Appeal Decision

Appeal Ref: APP/R5510/W/22/3295059

The Old Vinyl Factory, Blyth Road, Hayes, UB3 1HA

- The application sought planning permission for details of podium access plan without complying with a condition attached to planning permission Ref 59872/APP/2020/342 dated 19 June 2020.

Title	Proposed 2nd Floor Plan		
Site	The Assembly Buildings, Hayes		
Drg.	WH199/21/P/25.03d		
Date	Nov 2021	Rev	-
Drawn	JM	Scale	1:200 @ A2

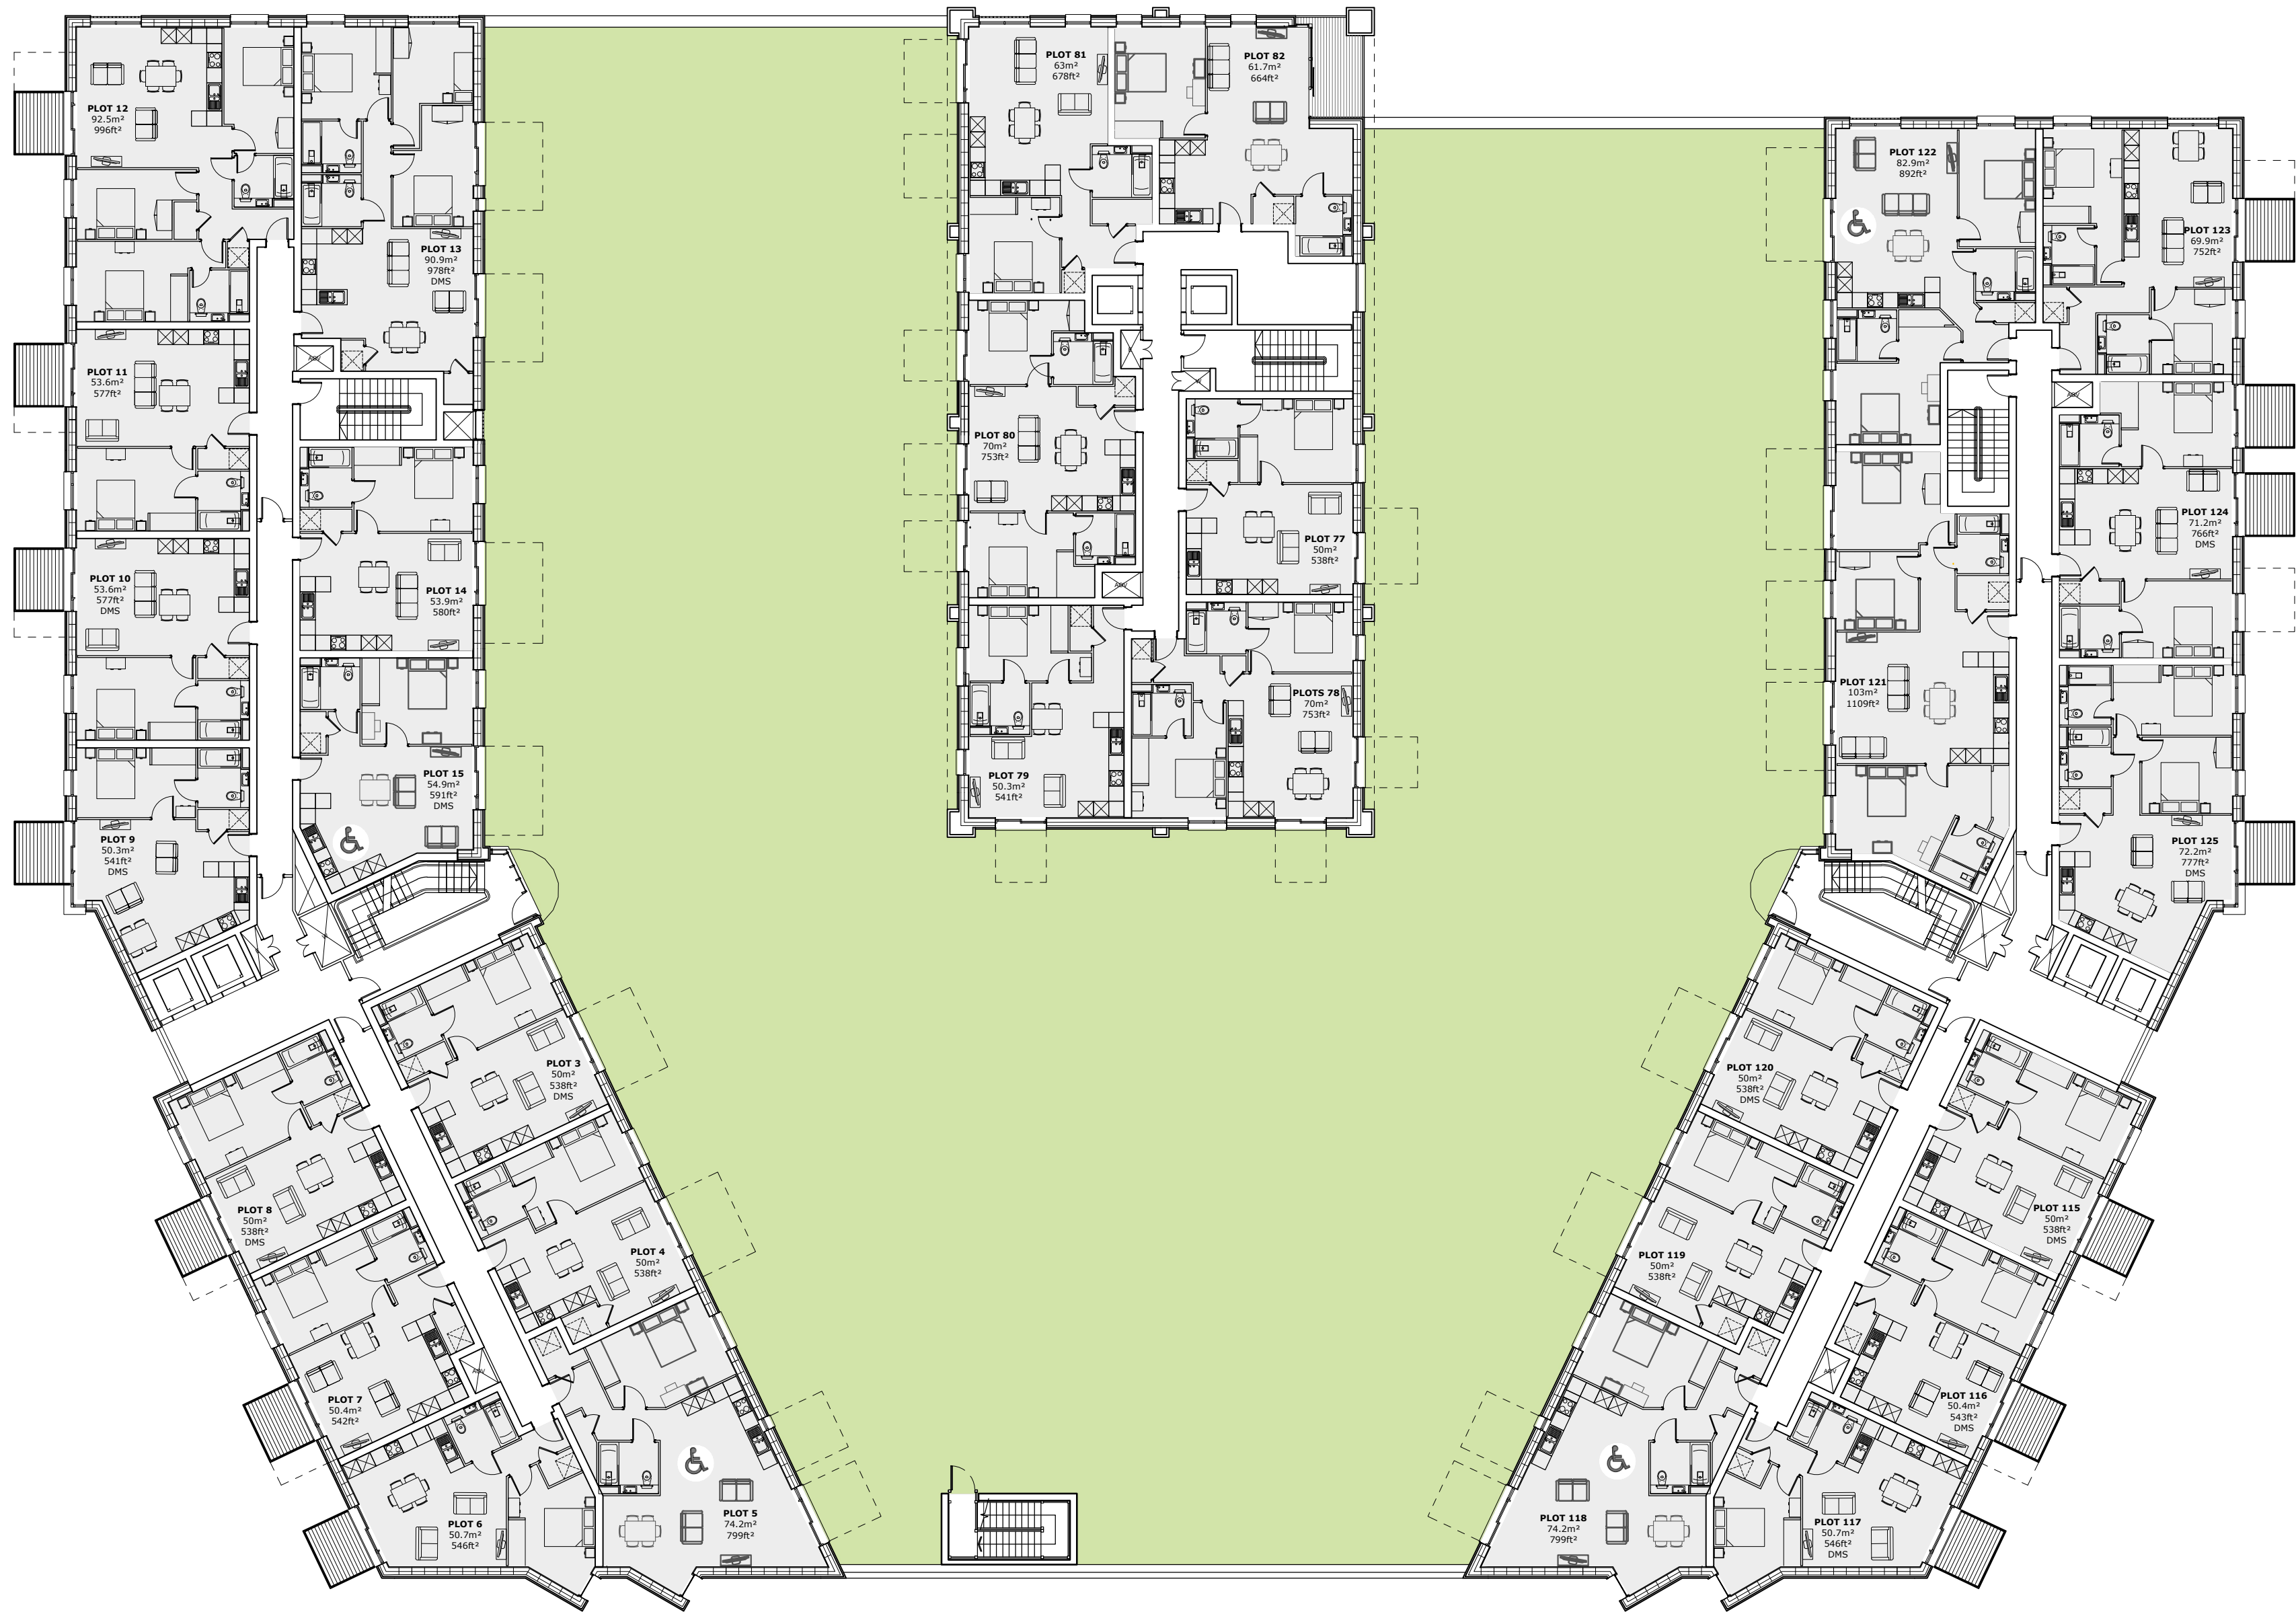
12. The application contained details of a new stairwell, located on Gramophone Lane, which would provide access via stairs to non-residents of the Assembly Building. This is not a main frontage of the building and as a result the access has the appearance of a secondary fire-escape or service entrance, rather than a main access point to the building. Even though the road would also be used by those accessing nearby office buildings, it would not be inviting to users.

13. The appeal submission contains further information on the management regime for access. This would include provision of a key-fob to secure access to the stairwell for those who have pre-registered for access to the facility. This is likely to deter those intent on crime, but it would also be likely to deter many from seeking access seeking casual use of the space. Furthermore, access for those unable to use the stairs would be achieved by contacting the management company to secure level access via the lift in the building's main lobby. Again, this would deter casual access to the space.

14. In this regard the arrangements put forward by the appellant are unlikely to achieve a significant degree of public access. I accept that the space itself is intended by the designers to have a semi-private character. I can therefore appreciate that unrestricted access may not be appropriate or desirable. Nevertheless, it seems to me that a separate, fob-only stairwell as proposed, away from the main entry points to the building, would not achieve a satisfactory standard of access even for users who have pro-actively sought use of the space.
